Comment	Topic
CDC SPD	<i>In relation to the Cherwell Residential Design Guide SPD 2018, officer comments that 'whilst the submission makes reference to this document as a material consideration, there appears to be no further to be no further reference to the Design Guide in the Design and Access Statement and therefore how the masterplan and design have evolved having regard to its requirements and advice.</i>
DAS update page reference	Notes
10	Updated text explaining the purpose of the CDC Residential Design Guide SPD
12	New page summarising Cherwell District character areas, updated design cue as per page 29
13	Updated text to contextual analysis with text derived from SPD. Notes that the site is within Cherwell District but also borders Woodstock, which is not within Cherwell District but is covered in the SPD and therefore is appropriate as a character analysis piece
21	Updated text stating townscape analysis focusses on local context of Woodstock (and Park View) with direct reference to SPD

Building density parameter plan

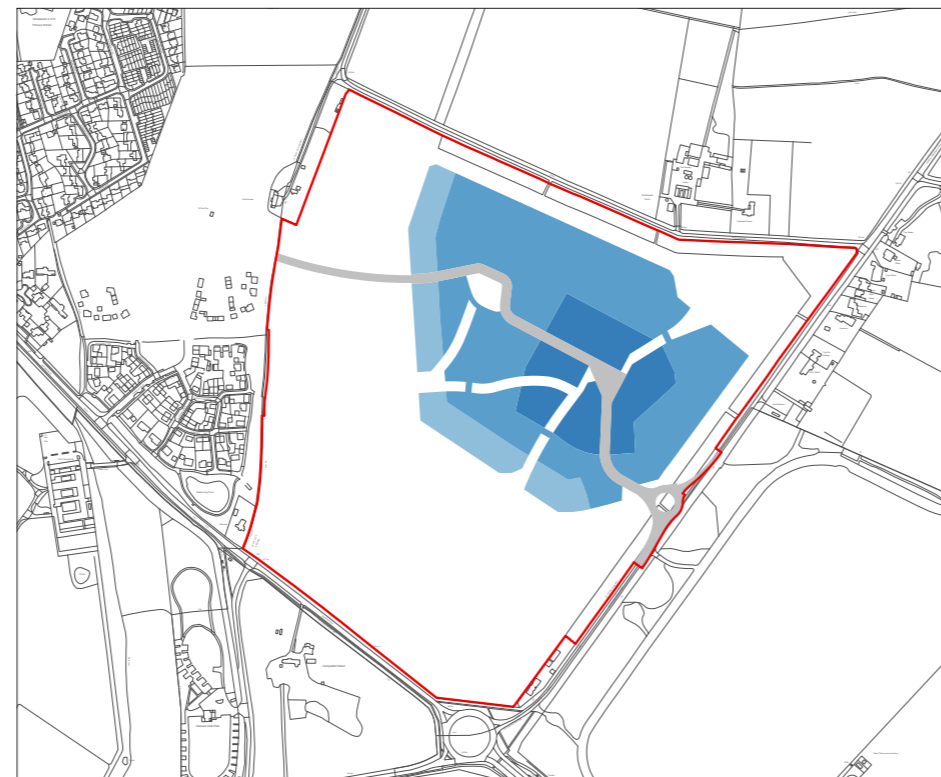
Item	Topic
Building heights and density	<p><i>It is noted that the heights of buildings generally within Woodstock are two storey but that some development around the central square is proposed up to 3 storey. Having regard to the relationship of this site within Woodstock and the open countryside, it is also considered that a density of 42dph within this central area would be out of keeping with the locality and open countryside and may also adversely impact on the setting of the World Heritage Site. There is no development of this scale within the vicinity of the site. If development was to be considered acceptable on this site it should not exceed 2 storey (8.5m) with occasional 2.5 storey marker buildings.</i></p> <p><i>Linda Griffiths subsequently advised in correspondence in dated 31/10/22: "In terms of building heights, you have not stated what they are at Park View, however, I consider that this site is quite different to Park View in terms of its relationship with Woodstock, existing built development and the open countryside. I therefore remain of the opinion that dwellings should not exceed 2 storey (8.5m) in height with the OCCASIONAL 2.5 storey as a marker building to aid legibility. In terms of density, as above, this site is not a direct comparison to Park View."</i></p>

29	Updated design cues with reasons for proposed building heights and density
55	Updated text in relation to surrounding building heights and density. References that CDC Residential Design Guide SPD expects residential density of between 30dph and 40dph. The average density of the masterplan is 34dph.
